26 June 2013

Our Ref: 130626PDADOPI&COS

**SICEEP – The Haymarket Stage 1 Stage Significant Development Application (SSD 5878 – 2013)
– Hyder Consulting response to stakeholder comments, recommendations and key issues.**

Project	SYDNEY INTERNATIONAL CONVENTION, EXHIBITION AND ENTERTAINMENT PRECINCT	
Title	EXISTING INTERNAL CATCHMENT PLAN SHEET 1

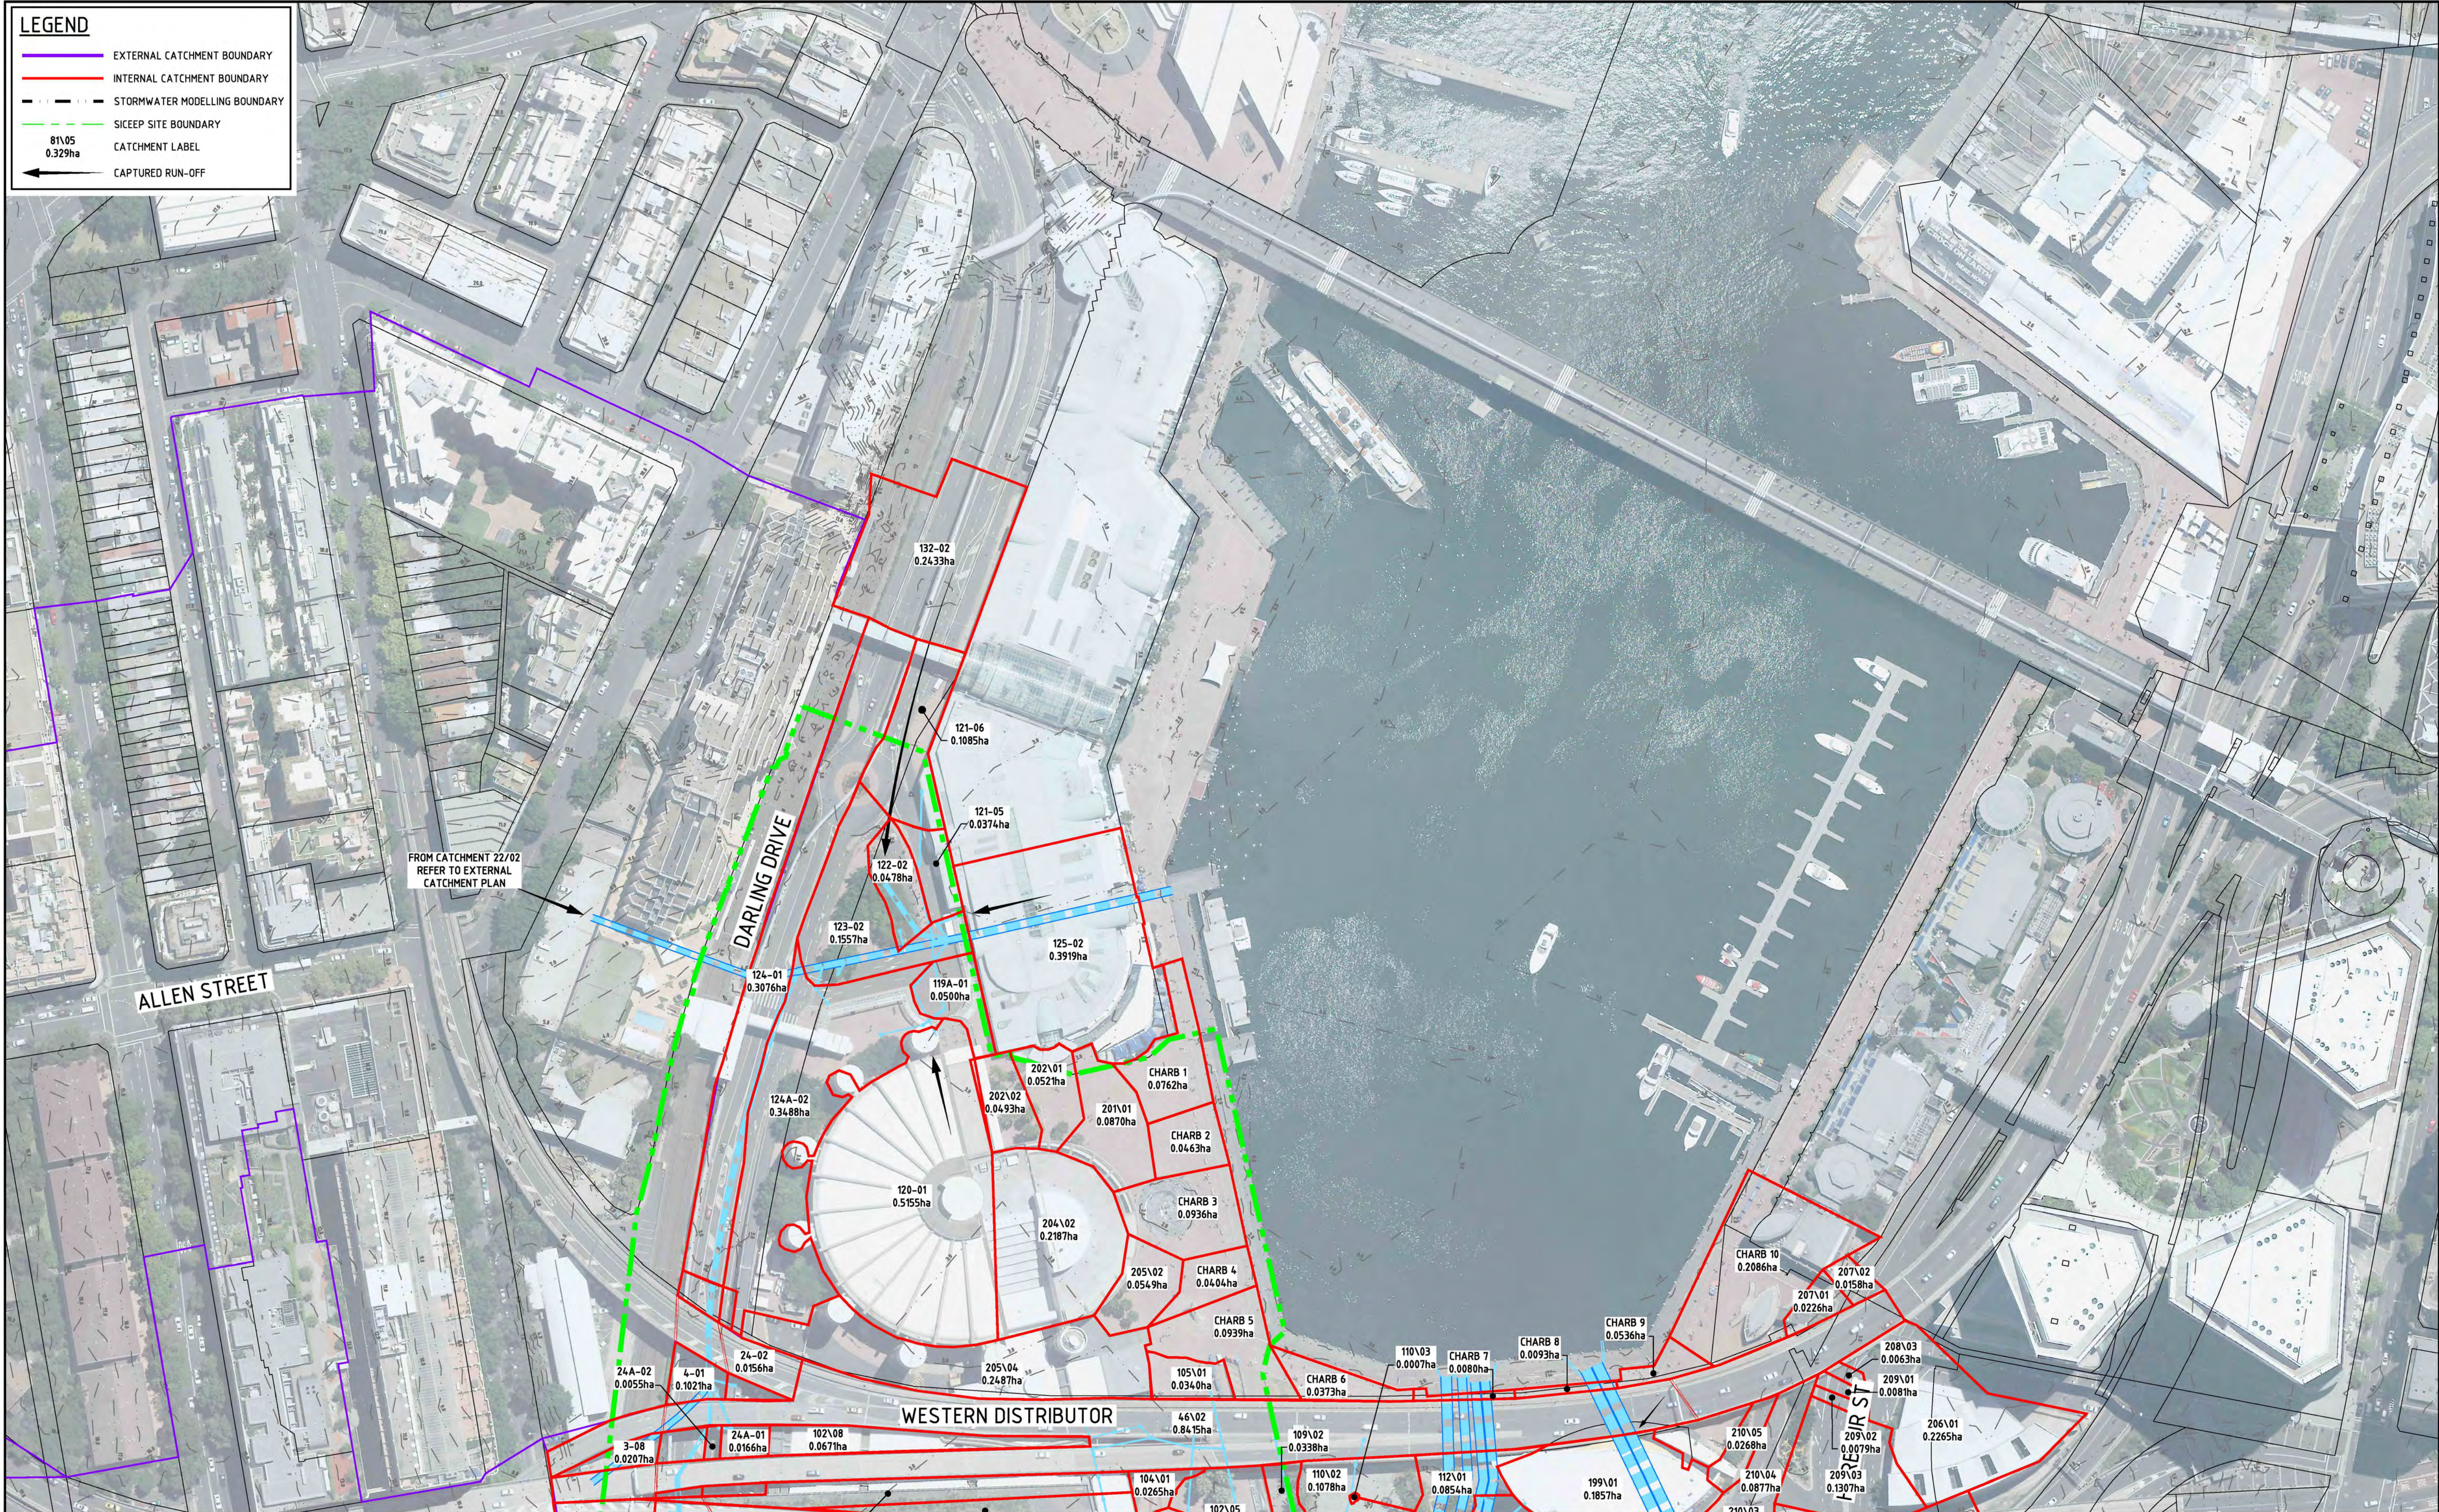
<p>25. With reference to Section 3.3.1 Model Setup - Inlet pit Blockage confirmation is required as to whether the modelling assumes all upstream catchment flows entering the Project site are contained within underground pipe systems with no overland flow component.</p>	<p>Not all existing trunk drainage systems have 20 year ARI capacity for runoff (when considering the entire catchment flow).</p> <p>The modelling of underground systems extends beyond the site boundary. In the TUFLOW model, all upstream catchment flows have been applied to the culvert. Once the culvert has reached capacity, the excess is applied to the surface. Therefore modelling includes overland flow from adjacent areas.</p> <p>Hyder do not consider it useful to complete modelling for the unrealistic condition of runoff</p>

DOPI Key Issue (Stormwater)	Hyder Response
	<p>from site only.</p> <p>For design purposes, at detail design stage, systems will provide 20 year ARI capacity except when limited by downstream system capacities.</p> <p>Catchment flows are not contained within the underground system. The underground systems have limited capacity and the modelling includes overland flows in excess of the underground capacity. The flood mapping provided in the Stormwater and Flooding Report addresses this comment.</p>
<p>26. Further explanation is required as to the key differences in hydrological and hydraulic representations between the existing and proposed case DRAINS and TUFLOW models (Section 3.4 potential flood impact).</p>	<p>The key differences between the existing and proposed DRAINS and TUFLOW models is that the proposed models include:</p> <ul style="list-style-type: none"> • A concept minor drainage system (pits, pipes and proposed building connections); • The proposed surface re-grading (including the proposed building ground floor footprints); • Revised sub-catchment boundary delineation to reflect the proposed building / public domain layout (noting that overall (total) existing and proposed catchment areas are the same); and • An amplification option. <p>All other parameters are consistent in existing and proposed models.</p>

PROJECT NUMBER	DRAWING NUMBER	REV
AA004399	WP-FL-0133	01

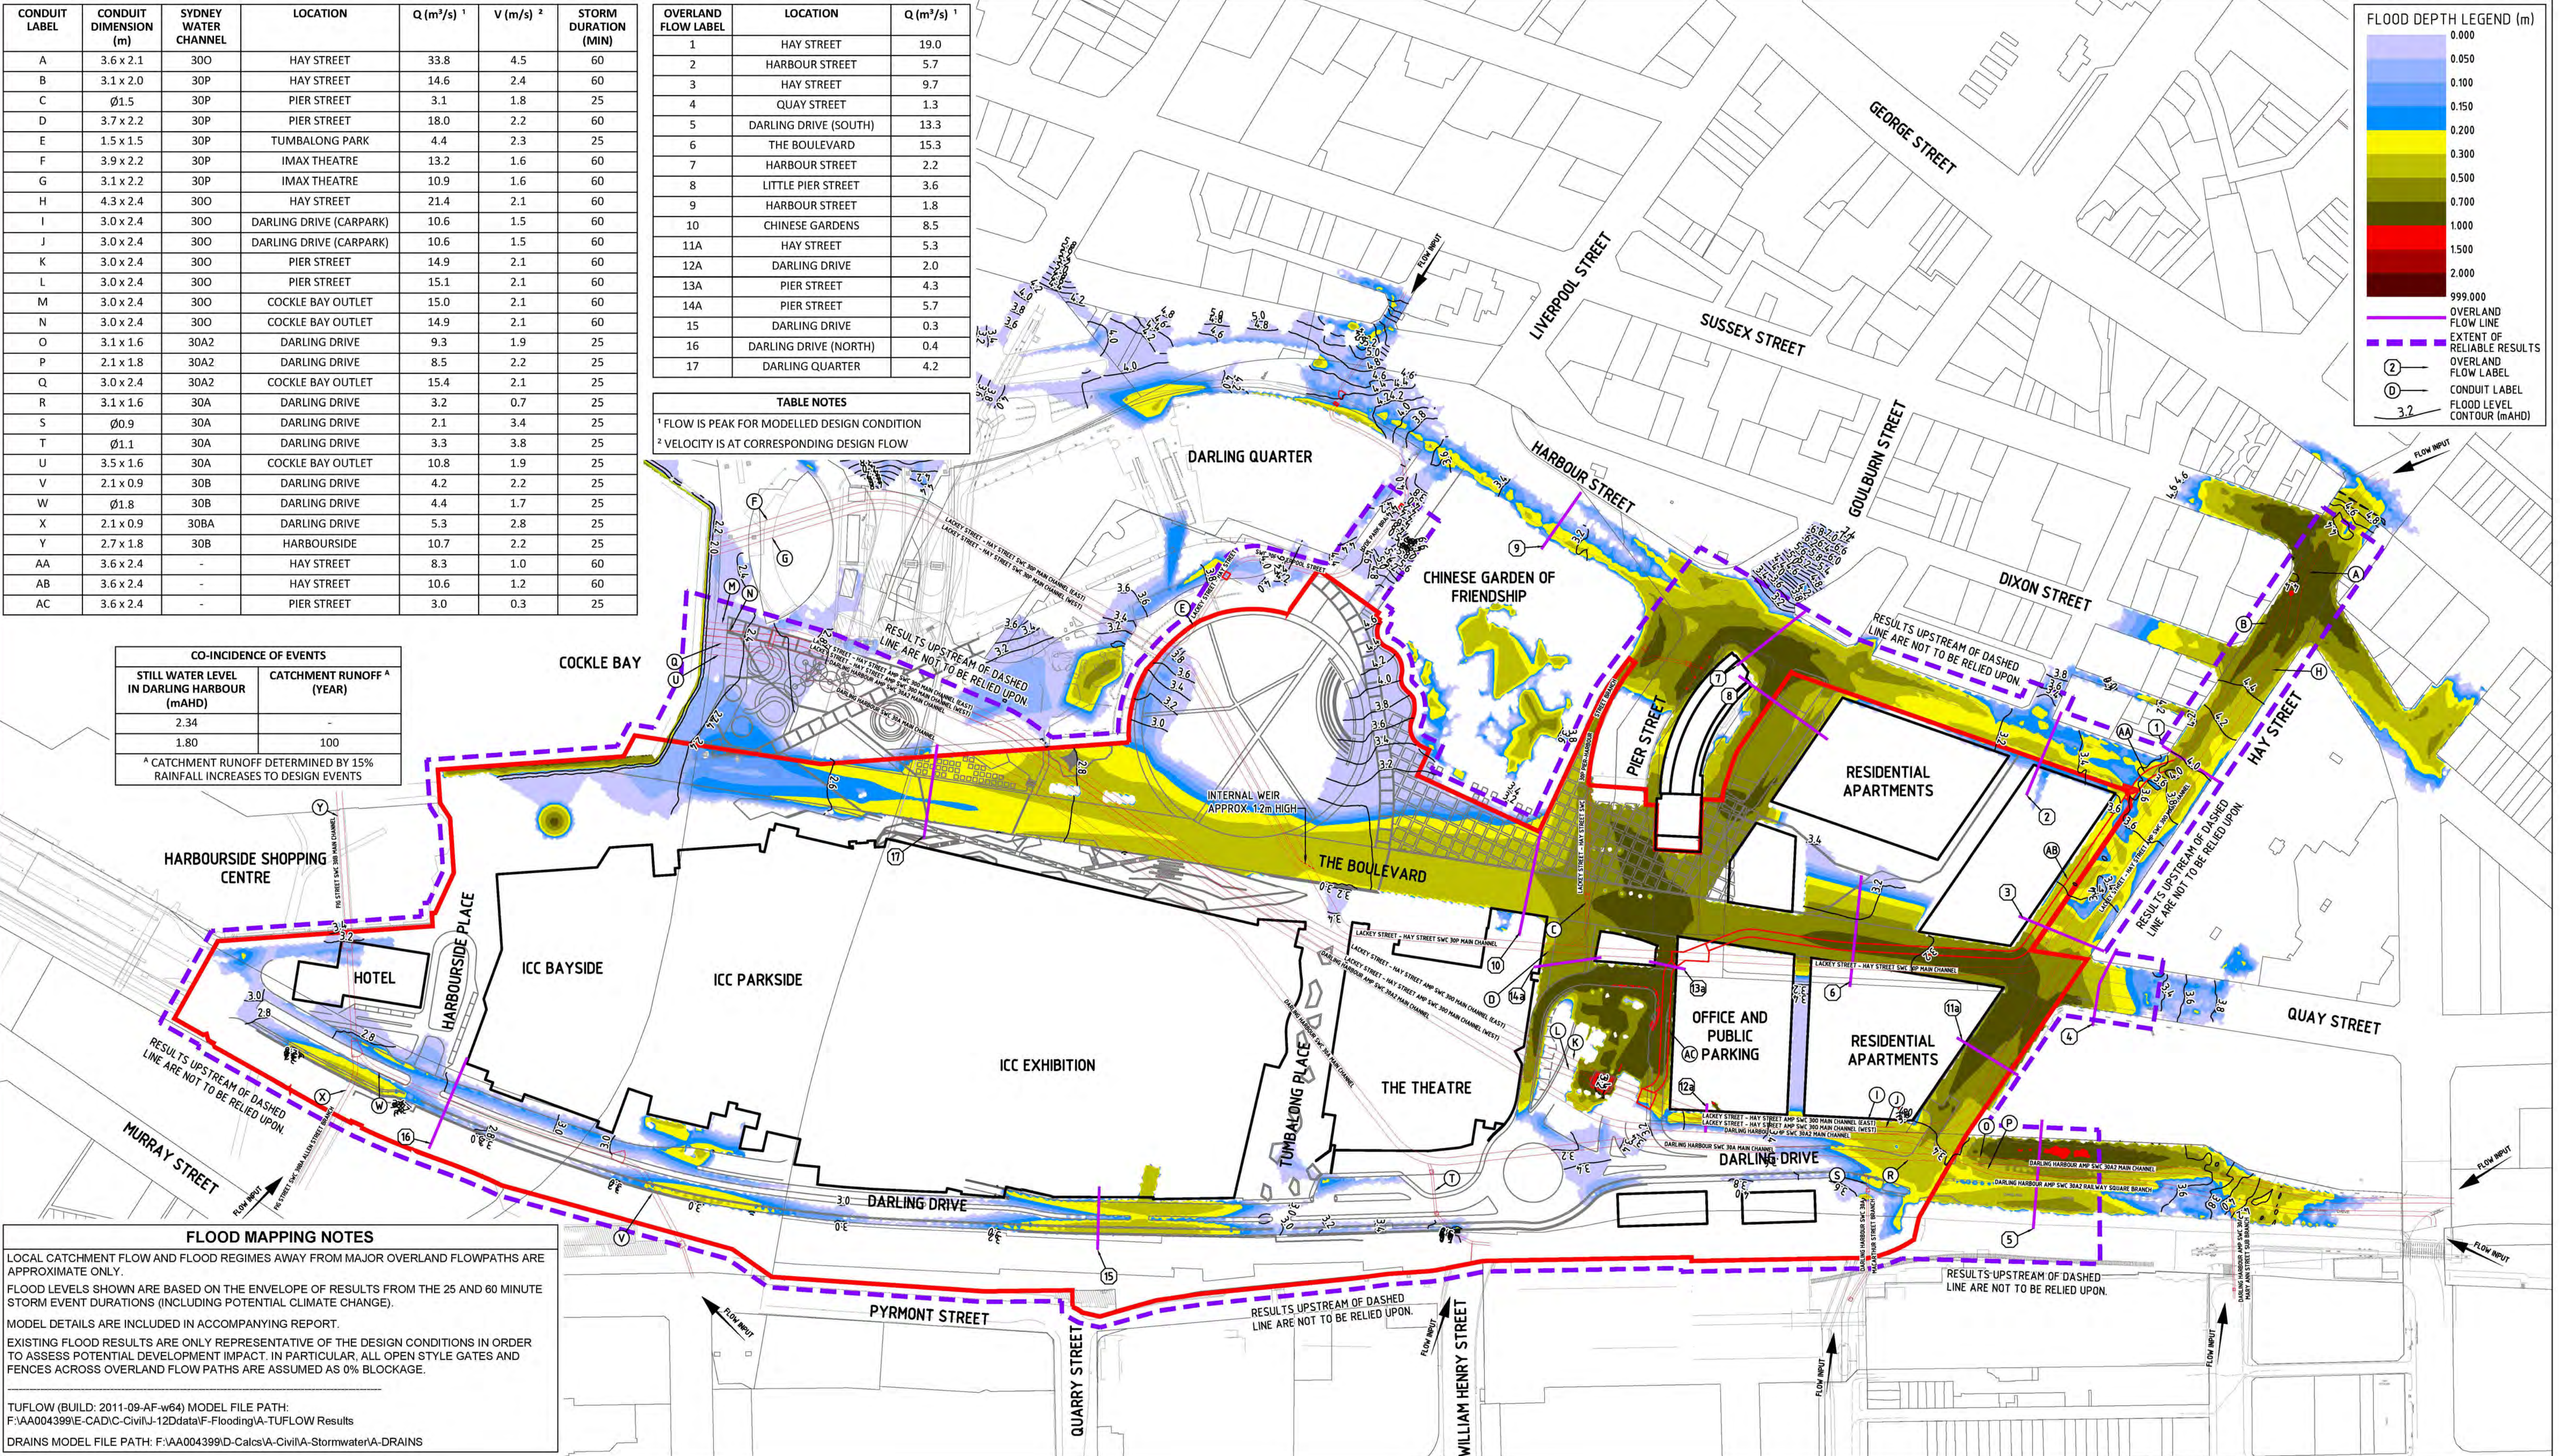
DOPI Key Issue (Stormwater)	Hyder Response
	design of WSUD treatment trains which achieve industry accepted / best practice water quality targets.
<p>29. With reference to the TUFLOW Model at Appendix C, clarification is required of the following:</p> <p>a) how potential climate change applied to the PMF event and whether this involved applying sea level rise only;</p> <p>b) it is unclear from the colour coding for localised flood Impacts what the maximum impact is at the northern end of the Boulevard (i.e. is it in the order of 0.5m or considerably higher). Identify the cause of the & flux and provide details as to whether is it possible to eliminate/mitigate at a later stage of the design; and</p> <p>c) what technique has been used to map the provisional hydraulic hazard (i.e. how were the hazard categories defined in Figure L2 of the Floodplain Development Manual translated to mapped outputs).</p>	<p>a) Hyder has applied sea level rise only to the PMF modelling.</p> <p>b) The afflux in this area has been investigated in the modelling and is suggested to be due to a change in the local drainage systems and catchment break-up. It is expected that with further detail this afflux can be mitigated/eliminated.</p> <p>c) The provisional hydraulic hazard mapping has been an output from TUFLOW (similar to flood depths and velocities) with the _Z1.dat function. The results (based on the maximum D x V) produce a number, of 1, 2 or 3, representing Low Hazard, Intermediate Hazard or High Hazard, respectively. These numbers have then been mapped based on the grid output.</p>
